FINDINGS OF FACT B&T Short Plat (S.P. 05-35)

B & T Short Plat
(SP-05-35)

Subject: B & T Short Plat (4 Lots); B & T Brunner Family
SR 903, MP 9.07 Right (Tom Write Road Intersection)

SUBJECT: B & T Short Plat

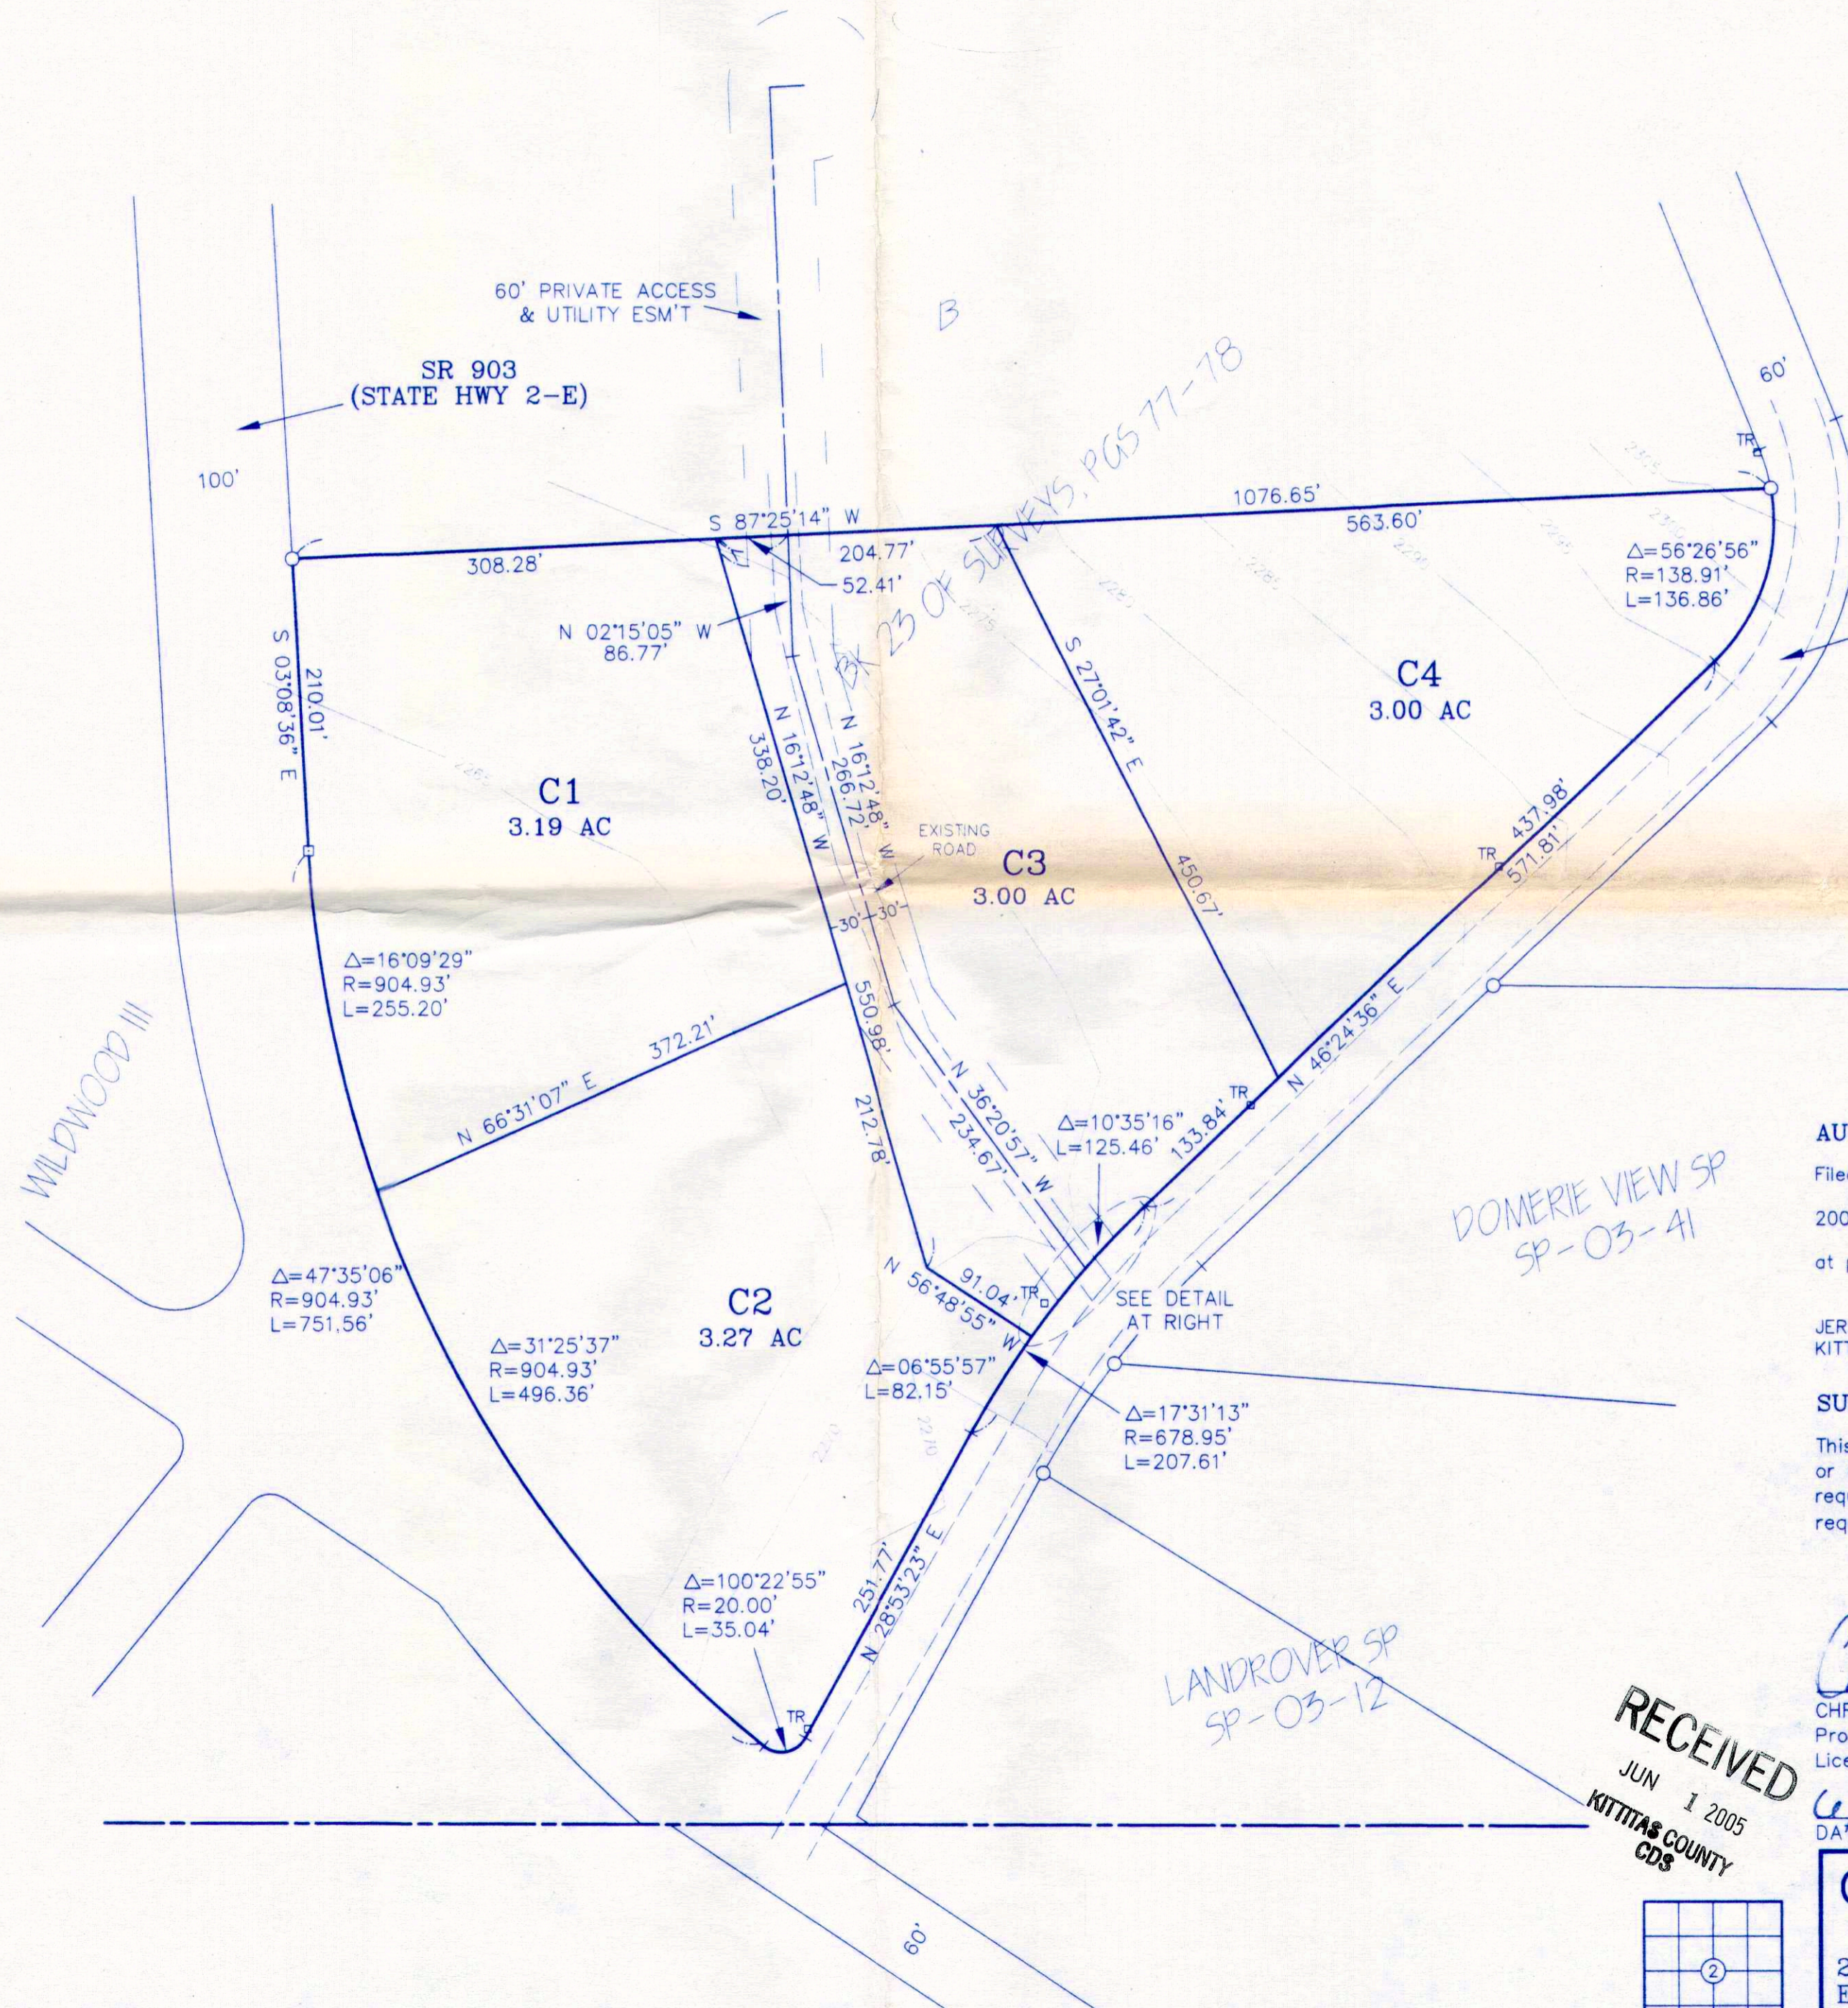
1. The plat property is adjacent to SR 903 and Tom Write Road. SR 903 is a Class 4 access managed highway in this location with a posted speed limit of 50 miles per hour. No direct access to SR 903 will be allowed. We require a restrictive note be placed on the plat indicating no direct access to SR 903 will be allowed for any lot.

The intersection of Tom Write Road does not meet minimum standards for even a private road approach. As a condition of development approval, WSDOT requires that the proponent pave the gravel portion of Tom Write to, at a minimum, the edge of WSDOT right-of-way. The proponent is required to contact Mr. Rick Holmstrom to coordinate the paving improvement. Mr. Holmstrom can be reached at 509-577-1633.

1. Private Road Improvements – Tom Wright Mine Road: Access shall be constructed as a Low-Density Private Road. (See current Kittitas County Road Standards)

- a. Access Easements shall be improved to a minimum of 60'. The roadway width shall be 20', with 1' shoulders = 22' total width.
 - b. All easements shall provide for AASHTO radius at the intersection with a County Road or State Highway.

- c. Minimum centerline radius will be 60'.
 - d. Surface requirement 6" gravel surface.
 - e. Maximum Grade 8% flat, 12% rolling or mountainous.
 - f. Stopping Site Distance, reference AASHTO.

- g. Entering Site Distance, reference AASHTO.
 - h. Maintenance of driveway approaches shall be the responsibility of the owner whose property they serve. The County will not maintain accesses.

- k. Proposed Short Plat is proposed to access off SR 903. SR 903 is a State Route and does not fall under County jurisdiction. Applicant shall submit an approved access permit from the Washington State Department of Transportation prior to final approval. Applicant shall be aware that access or lot configuration may need to be altered to meet WSDOT conditions for access. Applicant shall also be aware that access may not be granted from WSDOT. The Department of Public Works will not sign final mylars and give final approval without WSDOT approval.

2. Private Road Improvements – Private Access unnamed existing road: Access shall be constructed as a High-Density Private Road and serve no more than 14 tax parcels. (See current Kittitas County Road Standards)

3. Cul-de-sac for High Density Private Road: Typically a cul-de-sac is required with easement shown providing adequate turn around for the parcels on the plat. B & T Short Plat does not reflect any cul-de-sac at the northern boundary line. A temporary or permanent easement shall be shown on the face of the plat to provide for the cul-de-sac.

Lot C1 access is restricted to the private access easement. Access will not be approved off SR 903. **Plat Note**

Lot C2 access is restricted to the private access easement or Tom Write Mine Road. Access will not be approved off SR 903. **Plat Note**

The AFN Number for the 60' private access easement shall be shown on the face of the plat. **Update Plat**
